Your Ref
A/67/15/DOC
Our Ref
PLAN-010386
Date
09/07/2015

Proposal: Application for approval of matters reserved by condition imposed under A/167/14/PL relating to conditions 3, 4, 6, 10, 11, 12, 13, 14, 15, 18, 20, 21, 22 & 23 for schedule of materials, tree protection, prevention of surface water drainage on highway, construction of roads, footways/casual parking areas, Travel Plan, archaeological programme, ecological mitigation report, broadband speed, foul water sewerage disposal, surface water drainage, SUDs system, refuse & recycling bins & decentralised & renewable or low carbon energy source.

Site: Former Pound Nursery, Roundstone Lane, Angmering, BN16 4AL.
A/67/15/DOC

CLIENT	Barratt David Wilson Southampton				
PROJECT	Pound Nursery Roundstone Lane, Angmering				
TITLE	Site Layout Proposed Drainage Sheet 1 of 1				
DRAWN	A Davies	DATE	Dec 2014	PROJECT NO	22411
ENGINEER	G Waller	CHECKED		DWG NO	1221
SCALE	1:250 @ A1, 1:500 @ A3			REV	G

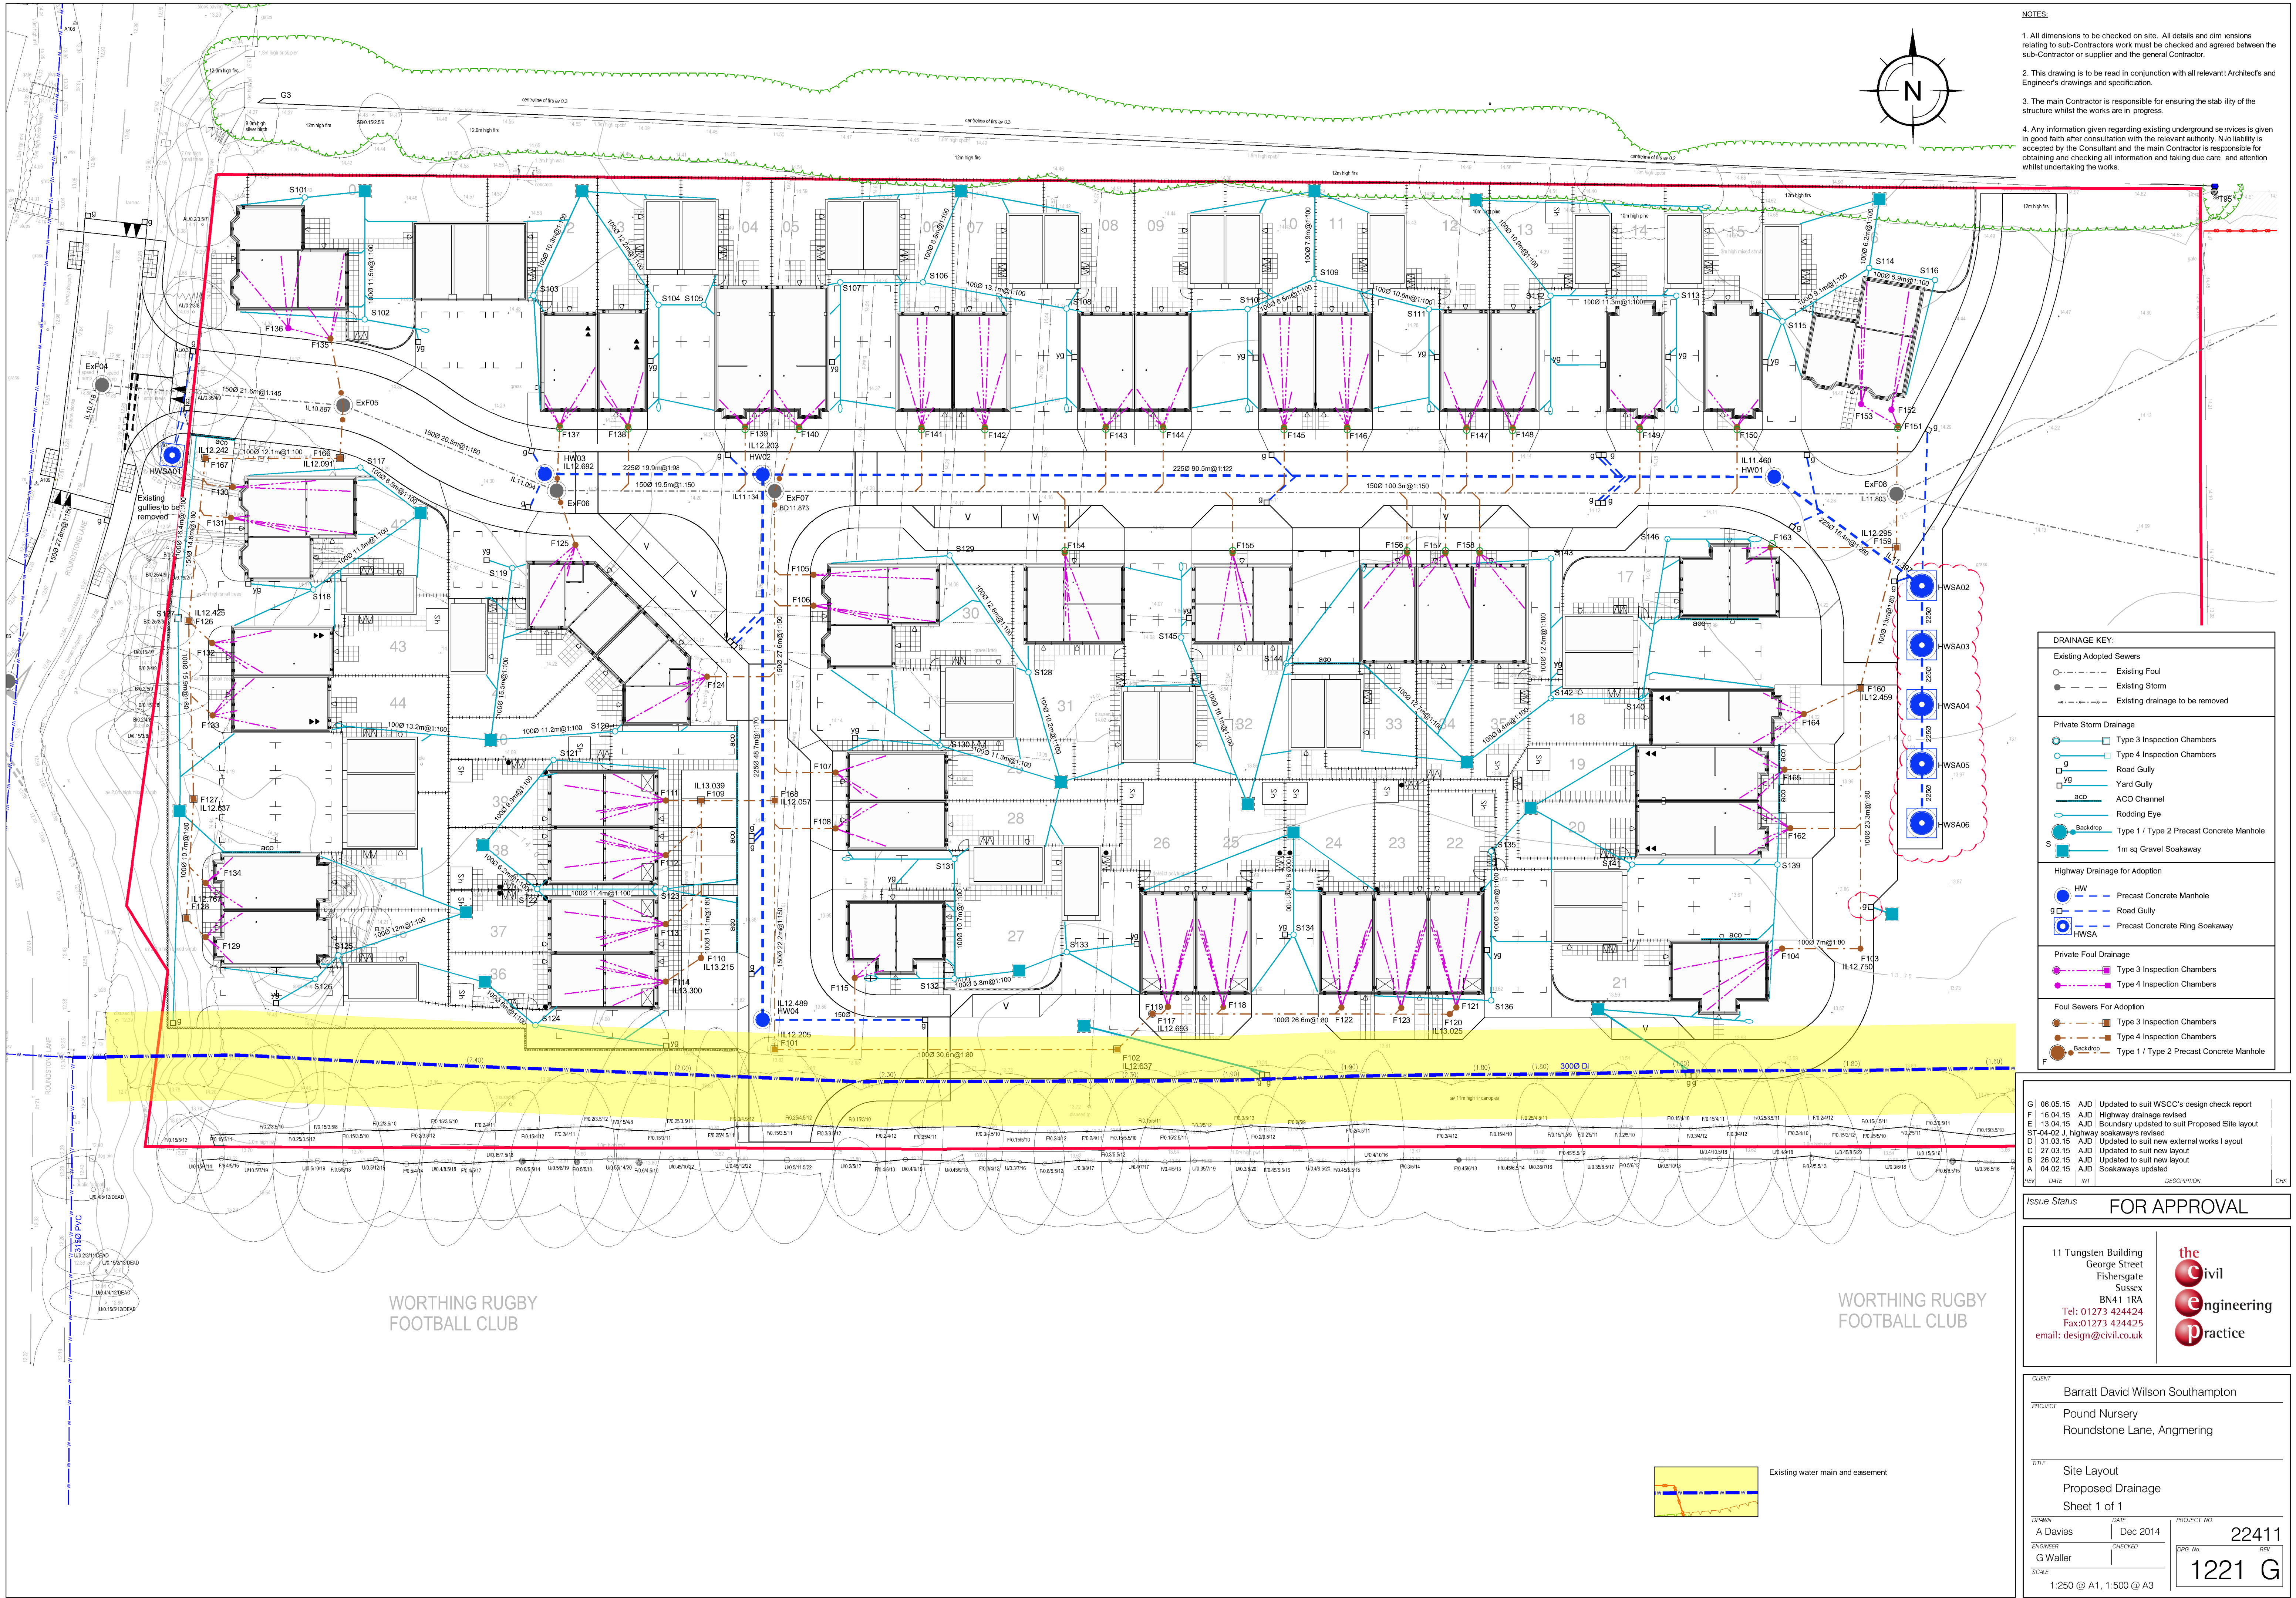
We regret that Southern Water cannot recommend discharge of foul condition as the drawing submitted does not comply with Sewer for Adoption standards.
